Application No: LU/50/21/PL

Recommendation Report for Planning Permission

LOCATION: Littlehampton Promenade
South of Putting Green
Sea Road
Littlehampton

PROPOSAL: Provision of 20 No. new beach huts on concrete bearers to broadly match existing.
This site is in CIL Zone 5 (Zero Rated) as other development.

Floor Plan & Elevations. Scale 1:50@ A3
Arun District Council Beach Hut Application

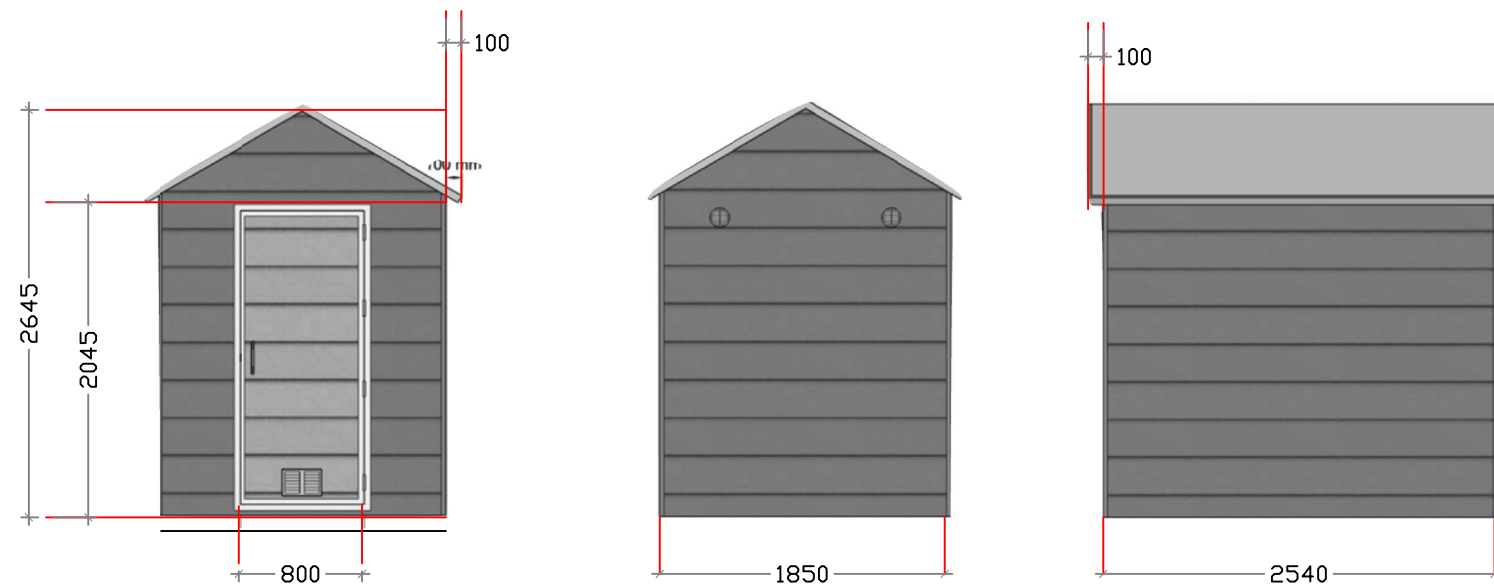
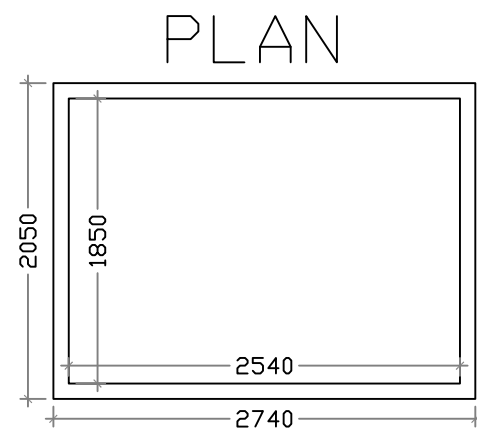
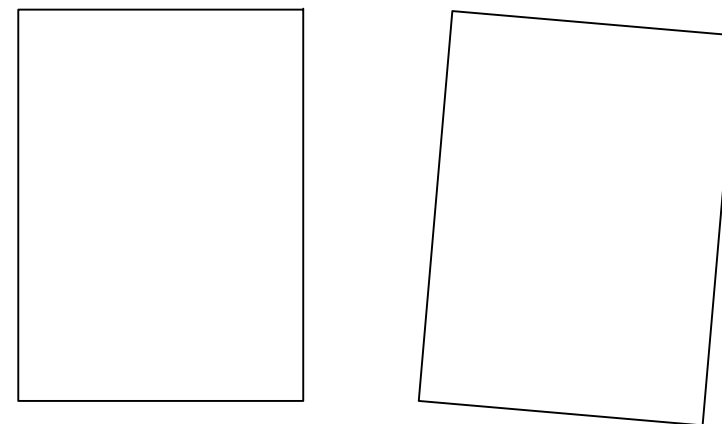
Provision should be made to facilitate wheel chair access. A minimum of three huts should be equipped with accessible facilities.

- The beach huts would match the existing in design and would be accessible for wheelchair users.
- There would still be gaps retained between the groups of huts allowing views of the sea and the proposal only deletes sea views of a small section of the whole promenade and Sea Road.
- The huts themselves are an important visual amenity feature as they contribute towards a traditional seaside resort appearance.
- The provision of the huts will not impair access to the beach or close it off from public use in any way.
- The proposal is compliant with policy LAN DM1 as it does not detract from the characteristics and natural features of the coastal landscape area.

Arun District Council Beach Hut Application
Block Plan (West Part). Scale 1:500 @ A3
Red Rectangles Represent Proposed Positions

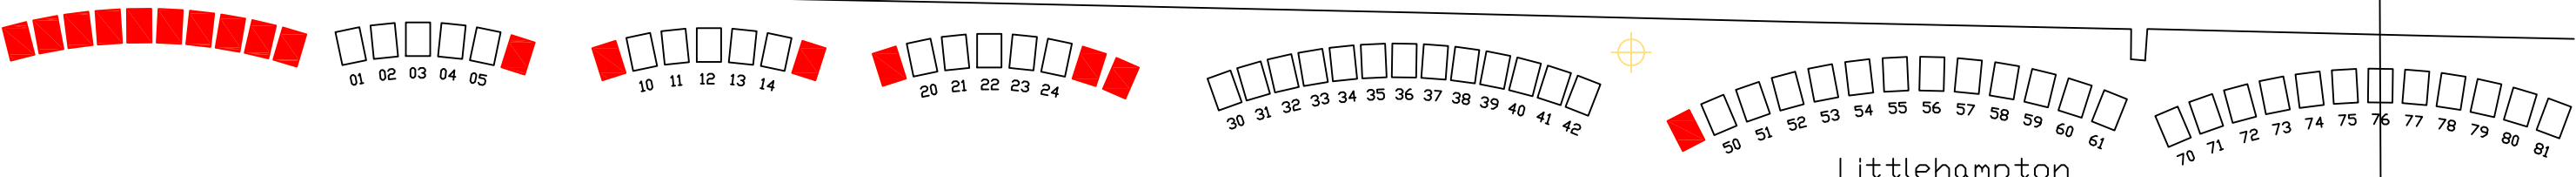
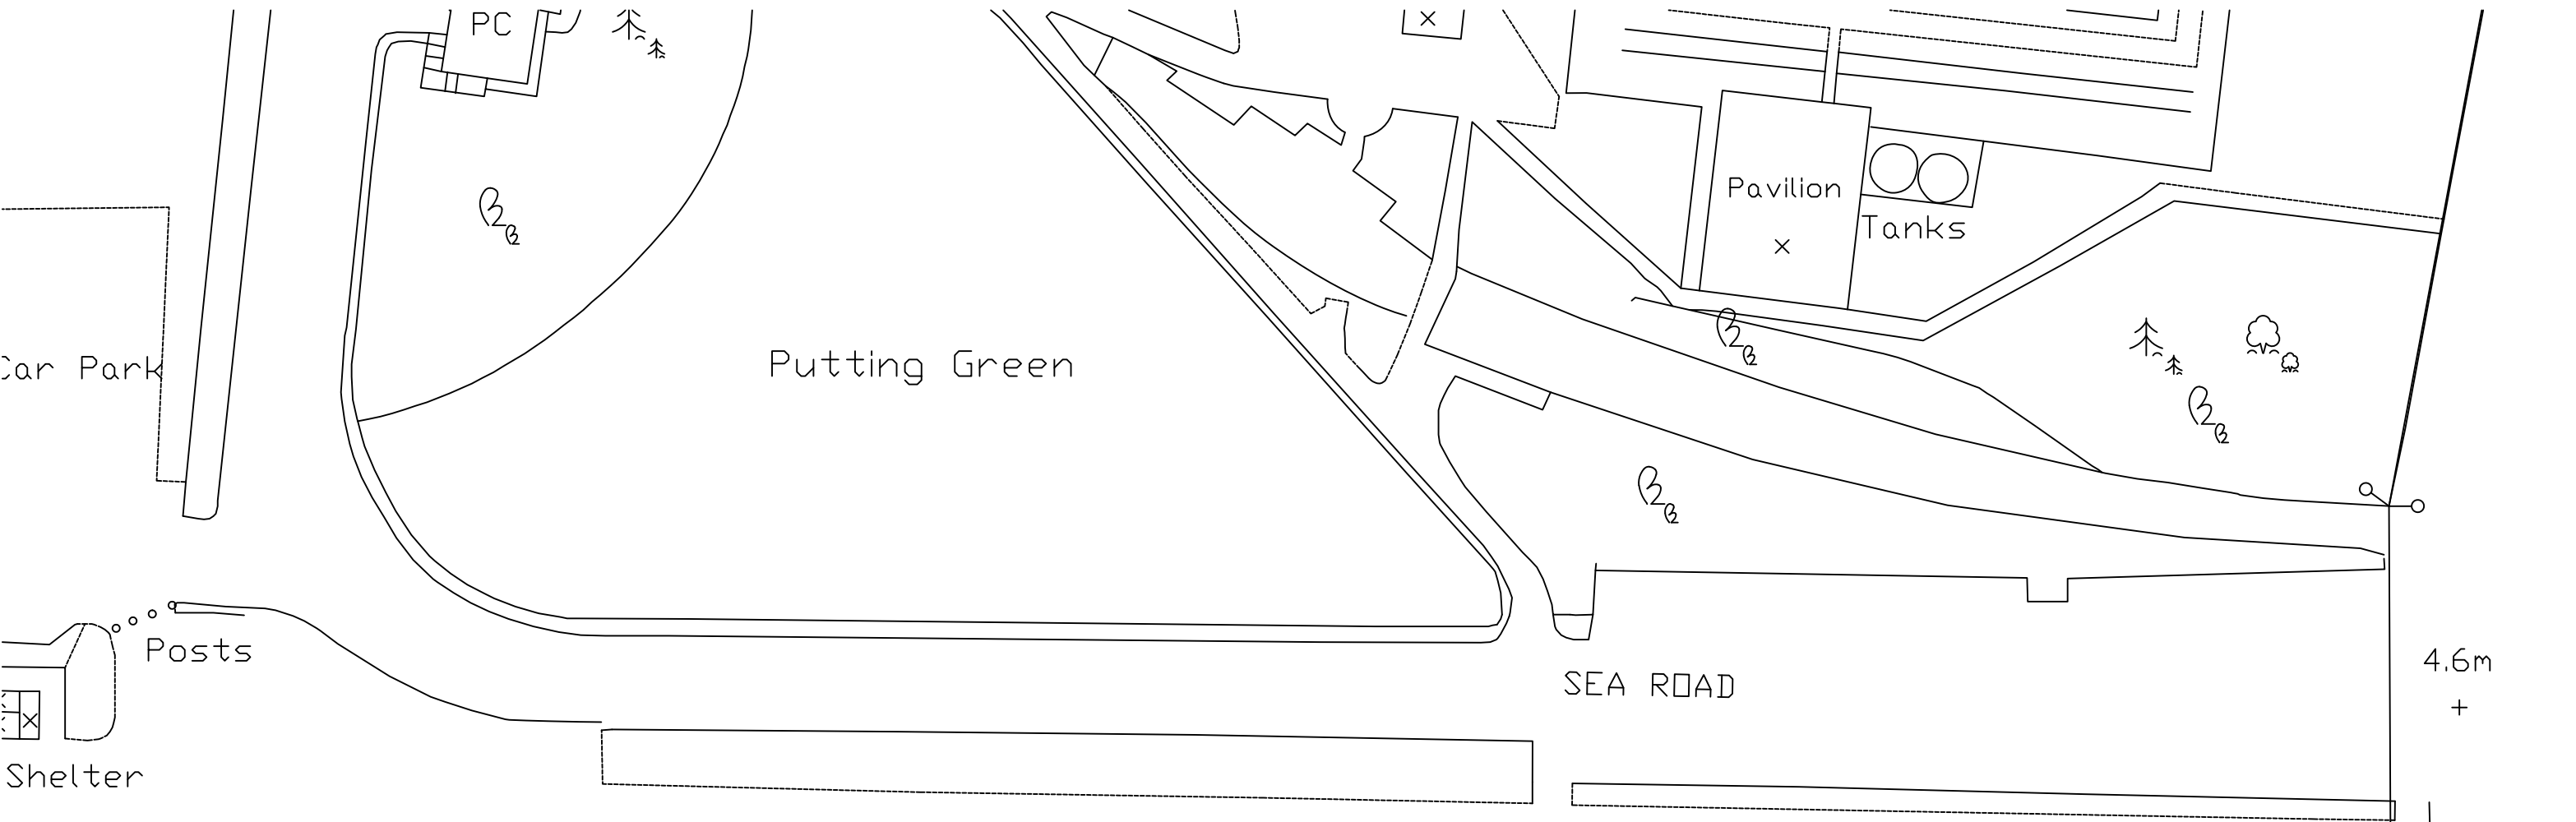
- Sea views should be available to all.
- The group of ten huts at the west end of the row is an act of destruction, because it will utterly ruin the only view of the sea and horizon from Street Level in the entire town.

- At the moment nearly 60% of the beach between the East Beach restaurant and the Skate Park is not visible, but if the project is carried through, the blockage will rise to 69%, meaning less than a third of the view is visible, and then only in the form of narrow gaps between huts.
